WEST SUSSEX COUNTY COUNCIL CONSULTATION

TO:	Arun District Council FAO: Maria Tomalova
FROM:	WSCC - Highways Authority
DATE:	6 July 2022
LOCATION:	20 Nyewood Lane, Bognor Regis, PO21 2QB
SUBJECT:	BR/61/22/PL Change of use to 5 bed house in multiple occupation.
DATE OF SITE VISIT:	N/A
RECOMMENDATION:	Advice
S106 CONTRIBUTION TOTAL:	N/A

Title
Block and Location Plans

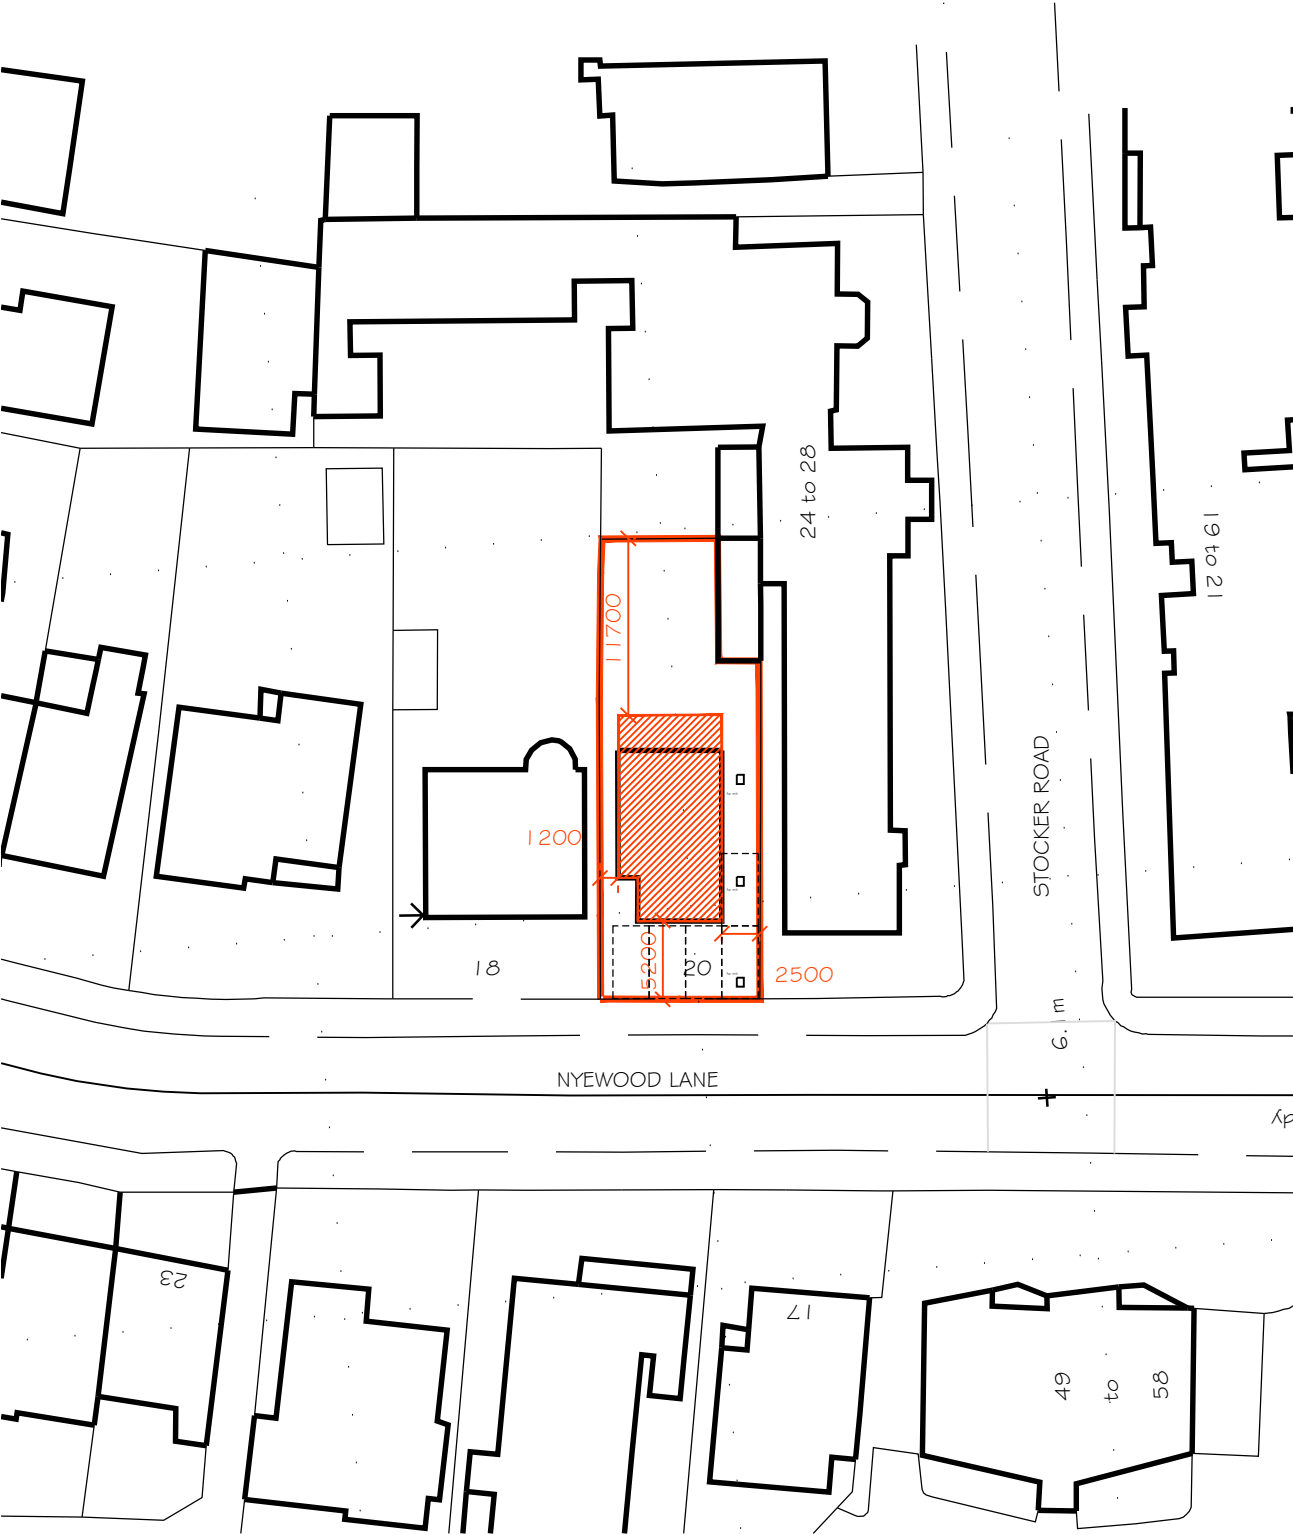
The applicant proposes no changes to the existing vehicular access arrangement fronting the site. The LHA advises that as four car parking bays are proposed along the site frontage, the access will require a widening of the existing dropped kerb, so that vehicles accessing the site do not bump the kerb. The access works will be subject to a licence obtained through the local Highway Area Office and constructed to a specification agreed with the local Highway Area Engineer.

From inspection of the plans, the four parking bays fronting the site appear suitably sized. The fifth parking bay to the side of the site has been demonstrated to the correct size but appears to have been drawn overlapping the building outline. Notwithstanding

this, the plans suggest that the side access way is suitably sized to accommodate a parking space, and historic mapping suggests this has been occurring for some time. As such, the LHA considers the proposed parking provision to be sufficient.
